Re: Notification of Proposed Bringelly Road Warehouse and Distribution Facility (SSD-37558583)

Liverpool City Council was invited to provide comments to the notification of a Major Project (SSD-37558583) proposal for the development of a warehouse and distribution facility at Lot 1 Skyline Crescent, Bringelly Road Business Hub (Lot 1 DP1266533).

Attachment – Detailed comments

Figure 4 Proposed waste storage locations

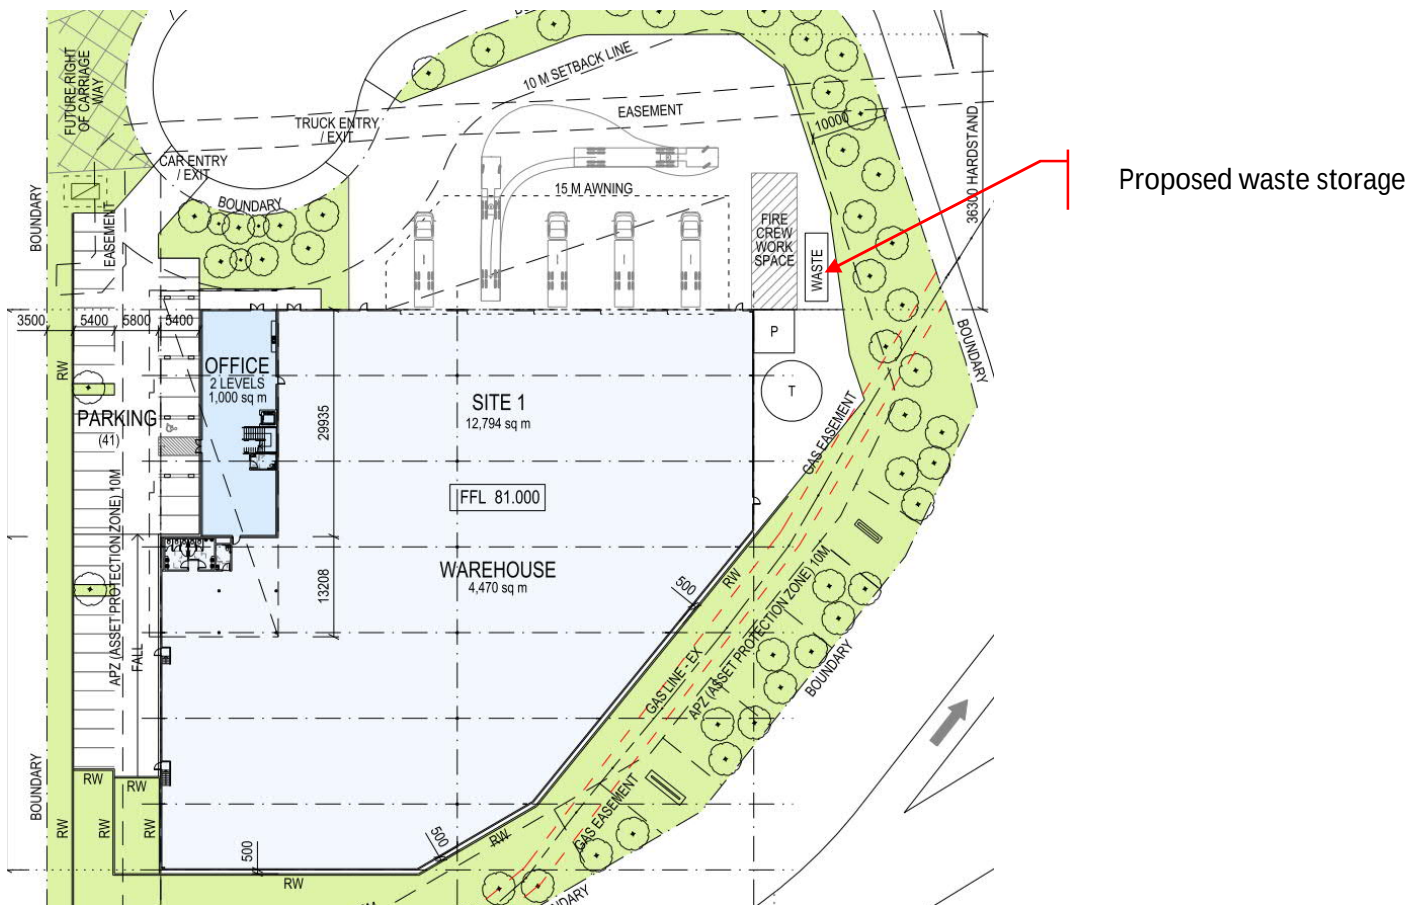
Suitable waste storage facilities need to be provided as part of the proposal.

25. The garbage/waste storage areas are required to be clearly identified on the site plans and be located within the proposed building.
26. The designated garbage/waste storage areas must comply with the following requirements:
- a) The rooms shall be fully enclosed and provided with a concrete floor, and with concrete or cement rendered walls coved to the floor;
 - b) Provided with a hose cock for hosing the garbage bin bay and a sewer drainage point in or adjacent to the bin storage area. The drainage point should have a fine grade drain cover sufficient to prevent coarse pollutants from entering the sewer. If the hose cock is located inside the bin storage bay, it is not to protrude into the space indicated for the placement of bins;

LANDSCAPE PLAN 01

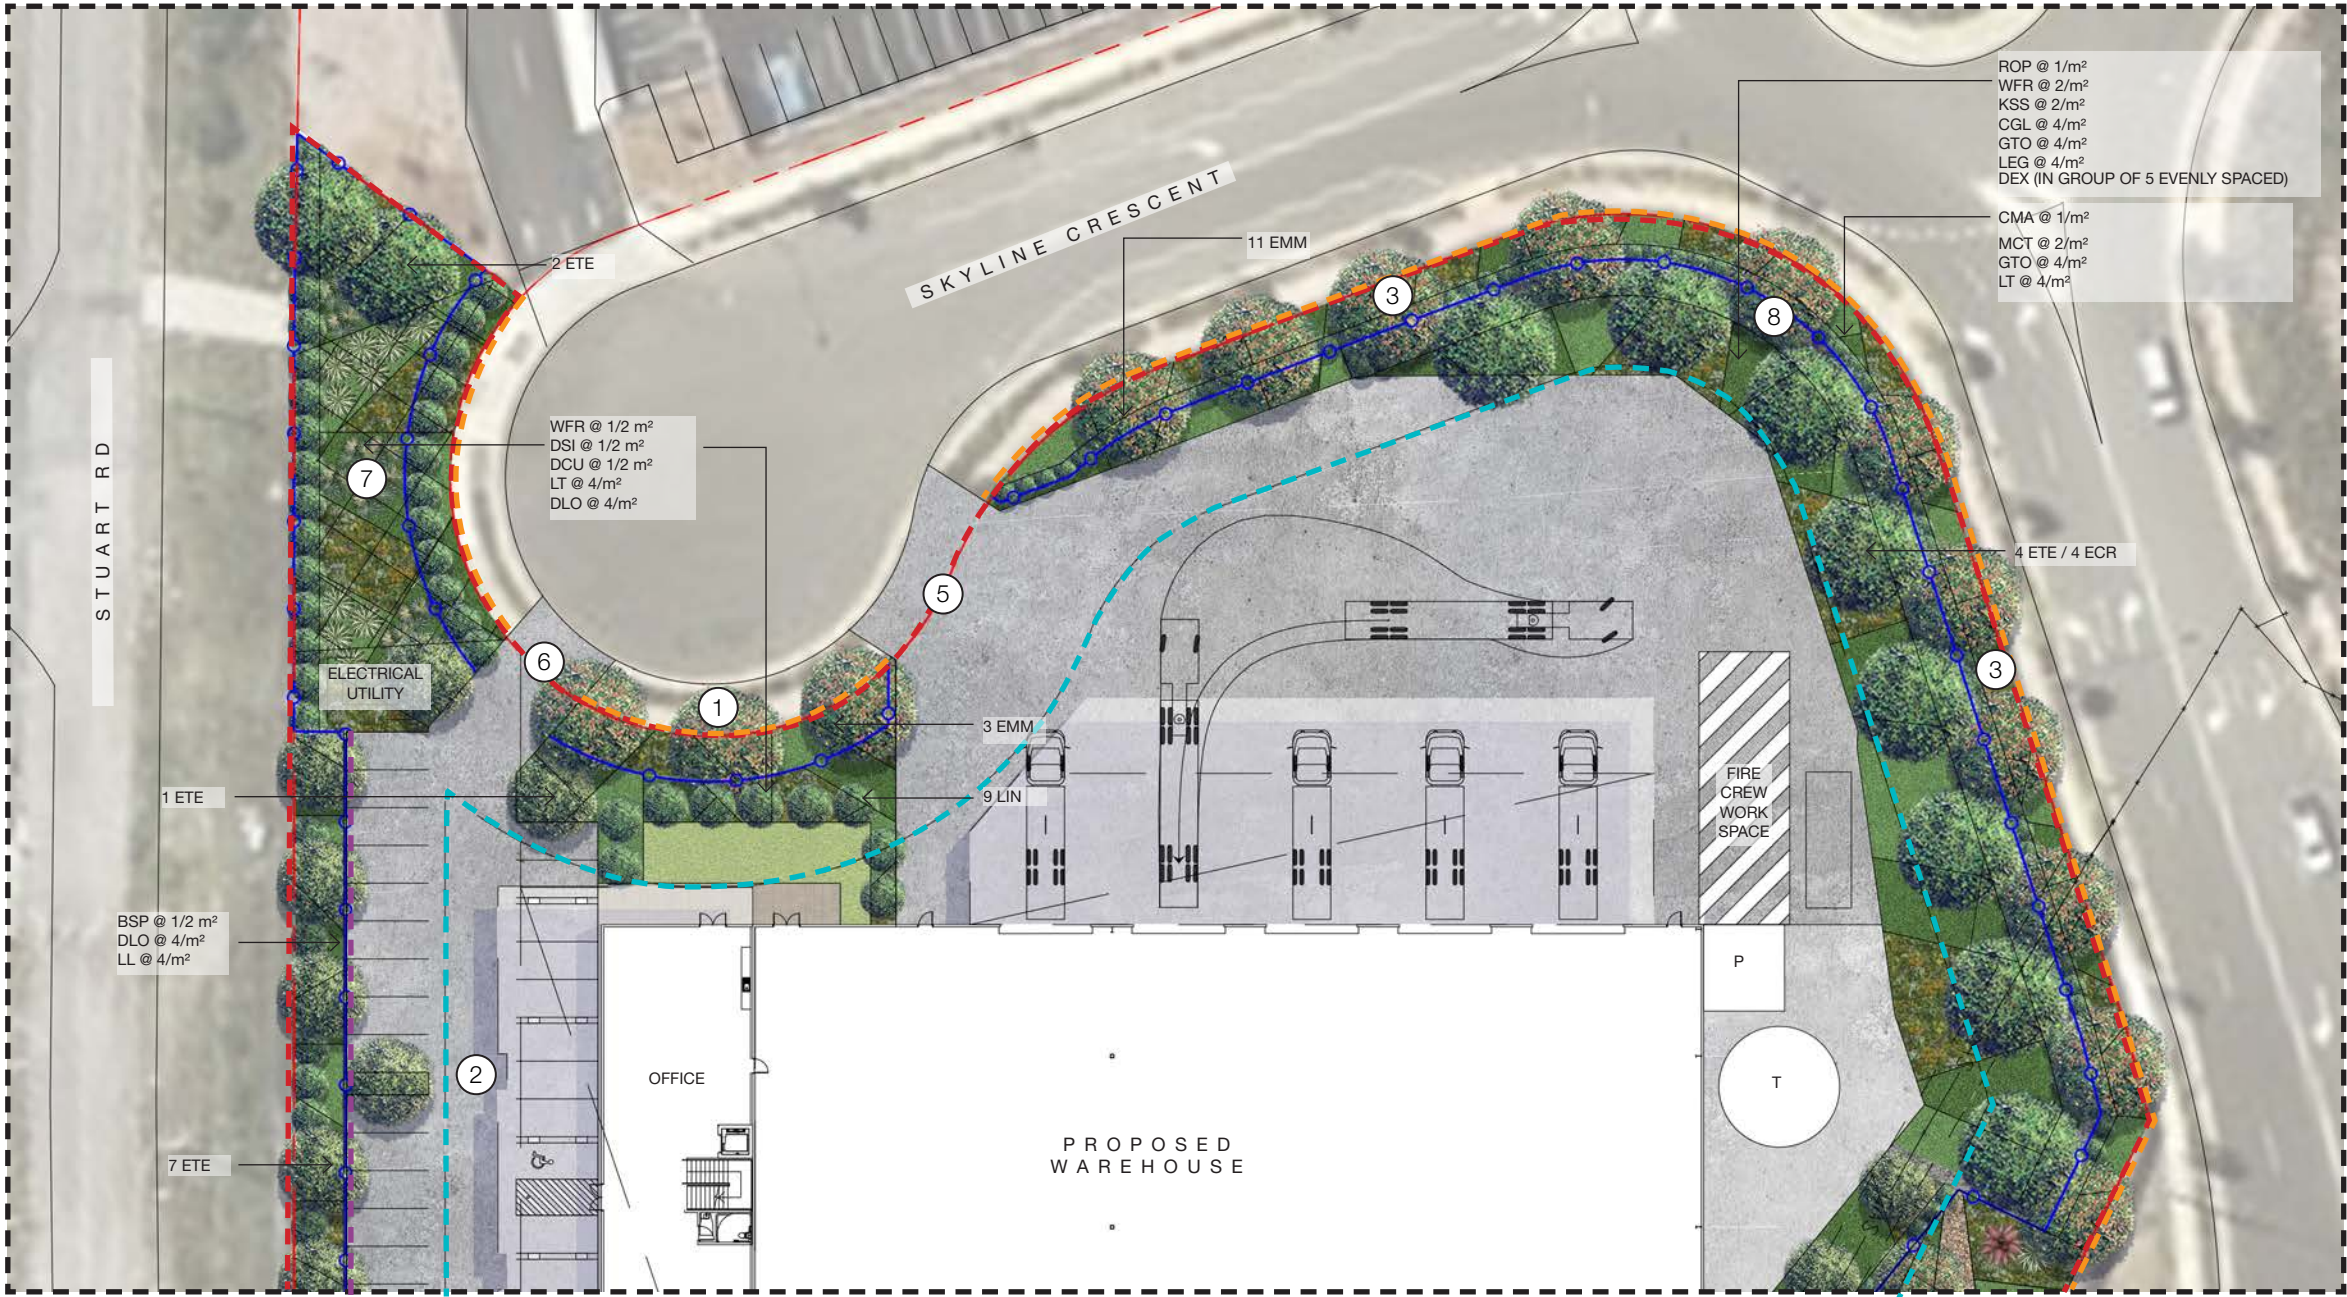
The proposed landscape plan indicates considerable tree planting within the APZ along the southern lot boundary. This portion of site has a significant grade which is being retained very close to the building line (i.e., with a gap of 500mm only).

Western Sydney is identified to be impacted by urban heat. The proposed car parking layout within the development indicates trees being provided within the car park after every 9th car parking bay. A considerable amount of paved area along the northern frontage (i.e., for the trucks to manoeuvre around the site) is being proposed. Providing natural shades and minimising amount of asphalt would reduce the urban heat island effect.

The landscape plans indicate *Magnolia* 'Little Gem' and *Tristanopsis laurina* as some of the proposed species within the planting palette. It is observed that these species are not performing well within the climate of Liverpool.

The landscape plan indicates 2.7m high palisade security fence being proposed along the perimeter of the site which considered to be of excessive height.

The landscape plan indicates two locations for Pylons signs being proposed as part of the development. The number of signs needs to be reduced to minimise the visual bulk.

8. The verge adjacent to Bringelly Road and Stuart Road is considered suitable for additional tree planting as part of the development. Provide an updated landscape plan that indicates large canopy tree plantings outside the southern and western lot boundaries.

12. Additional trees are provided as part of the car parking layout (i.e., after every 5th car parking bay at 12m) to provide natural shade within the car park.

13. The landscape plan should indicate permeable paving for the proposed car parking bays to soften the extents of hard paved surface. Consider a strip of permeable paving within the northern frontage (e.g., for areas that are free from the turning paths of the vehicles) to reduce amount of asphalt being proposed. This will assist in reducing urban heat.

14. An alternative tree species is selected to replace the proposed Magnolia and Tristaniopsis species.
15. Include a set of translucent panels and or PV solar panels within the roof to allow natural light to enter the warehouse area, and to increase energy self-sufficiency.

16. The height of the palisade fence be changed to 1.8m high (in-line with the recommendations of Liverpool DCP) and the proposed colour for the fence needs to be 'Black Midnight Sky'.

17. Limit the number of Pylon Signs being proposed as part of the development. Consider removing one of the Pylon signs proposed along Bringelly Road.
18. Provide an adequately sized outdoor amenity space for the occupants of the proposed development.
